# CITY OF ALBUQUERQUE

**Re: Johnston Supply Warehouse**  
**2624 Vassar Dr. NE**  
**Traffic Circulation Layout**  
Engineer's/Architect's Stamp XX-XX-XX (H16-D062)

Based upon the information provided in your submittal received 07-20-23, the above referenced plan cannot be approved for Building Permit until the following comments are addressed:

SET NO:
SHEET TITLE:
TRAFFIC
CIRCULATION
LAYOUT

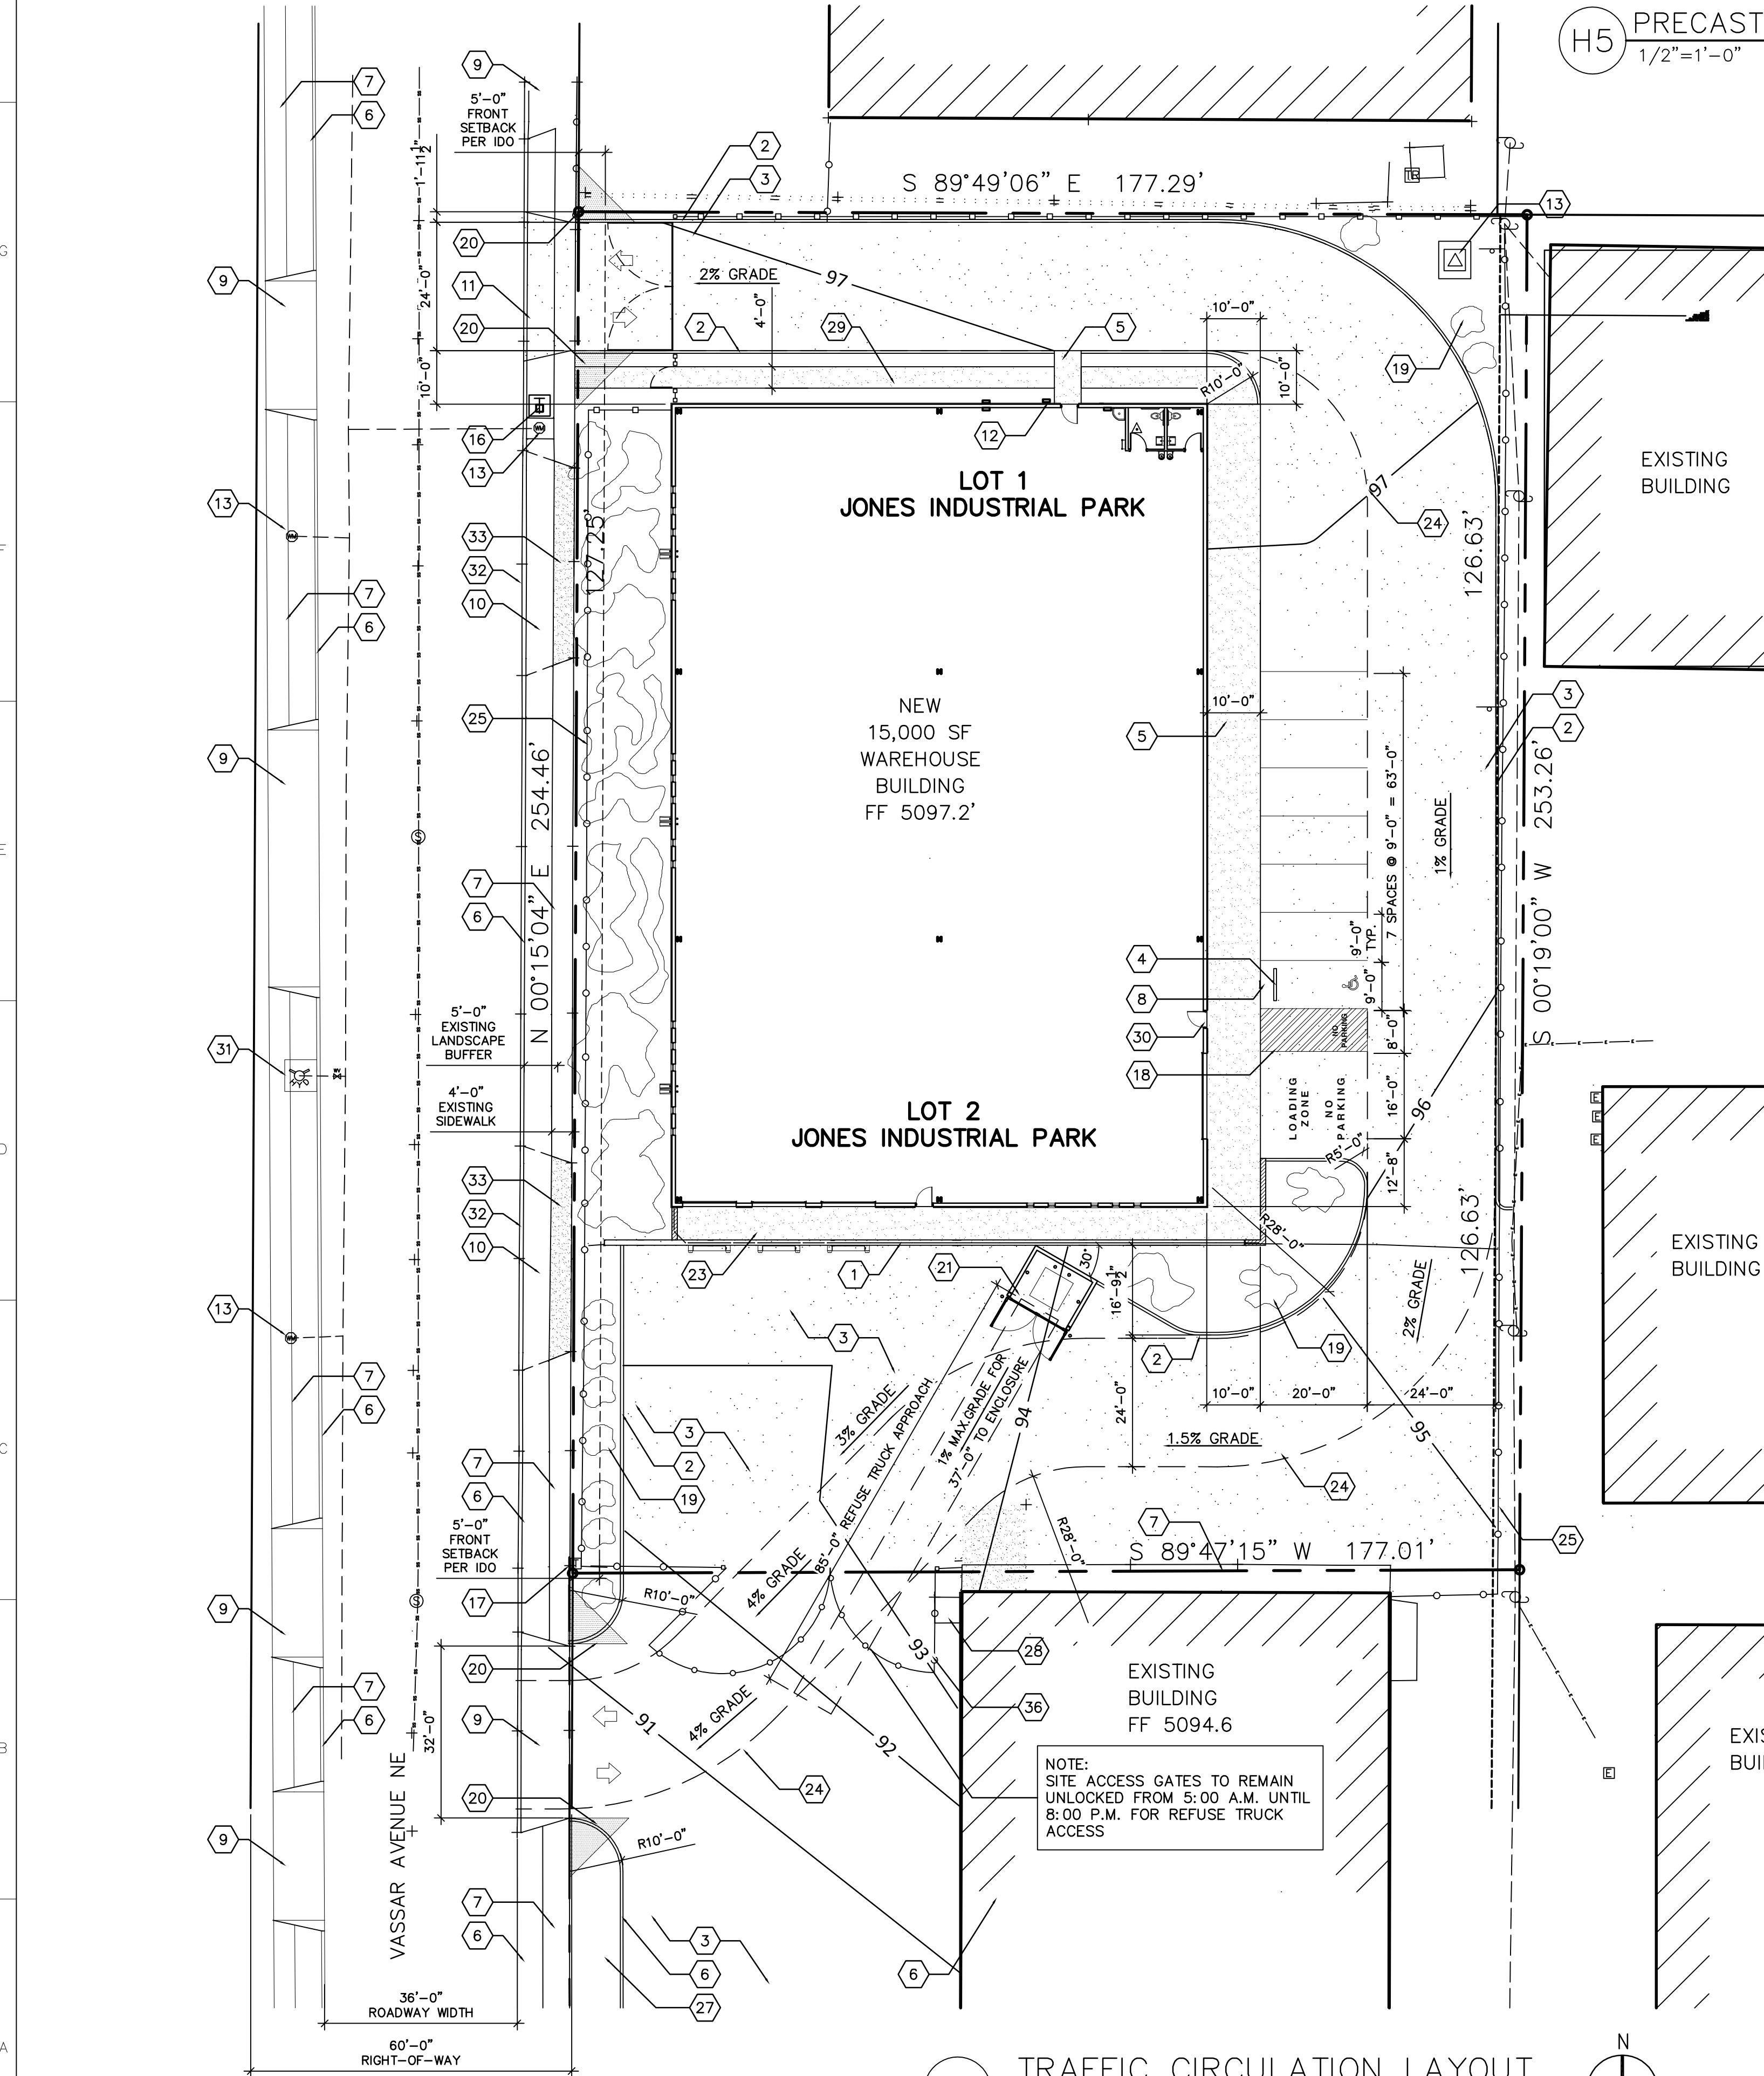
1. The traffic circulation layout must be stamped, signed, and dated by an engineer or architect licensed in the state of New Mexico.
2. Site accesses must be updated to the current standard. Please provide driveways design details and reference COA std dwg.

3. The ADA accessible parking sign must have the required language per 66-7-352.4C NMSA 1978 **"Violators Are Subject to a Fine and/or Towing."** Please call out detail and location of signs.

4. The ADA access aisles shall have the words **"NO PARKING"** in capital letters, each of which shall be at least one foot high and at least two inches wide, placed at the rear of the parking space so as to be close to where an adjacent vehicle's rear tire would be placed. (66-1-4.1. B NMSA 1978)

5. Per the IDO, a 6 ft. wide ADA accessible pedestrian pathway is required from the public sidewalk to the building entrances. Please clearly show this pathway and provide details.

6. Please show this pathway width on the site plan.

7. Curbing should be installed to delineate landscape, parking, and pedestrian ways and identify points of access. Please call out detail and location of barrier curb.

8. Refuse vehicle maneuvering shall be contained on-site. The refuse vehicle shall not back into the public right of way.; provide a copy of refuse approval.

9. Provide a copy of F
10. The clear sight triangle must be shown at the back of the sidewalk and add the following note to the plan: "Landscaping and signage will not interfere with clear sight requirements. Therefore, signs, walls, trees, and shrubbery between 3 and 8 feet tall (as measured from the gutter pan) will not be acceptable in the clear sight triangle.

11. Please specify the City Standard Drawing Number when applicable.
12. Unused curb cuts must be replaced with sidewalk and curb & gutter. A build note must be provided referring to the appropriate City Standard drawing.

13. Add a note stating "All broken or cracked sidewalk must be replaced with sidewalk and curb & gutter." A build note must be provided referring to the appropriate City Standard drawing.
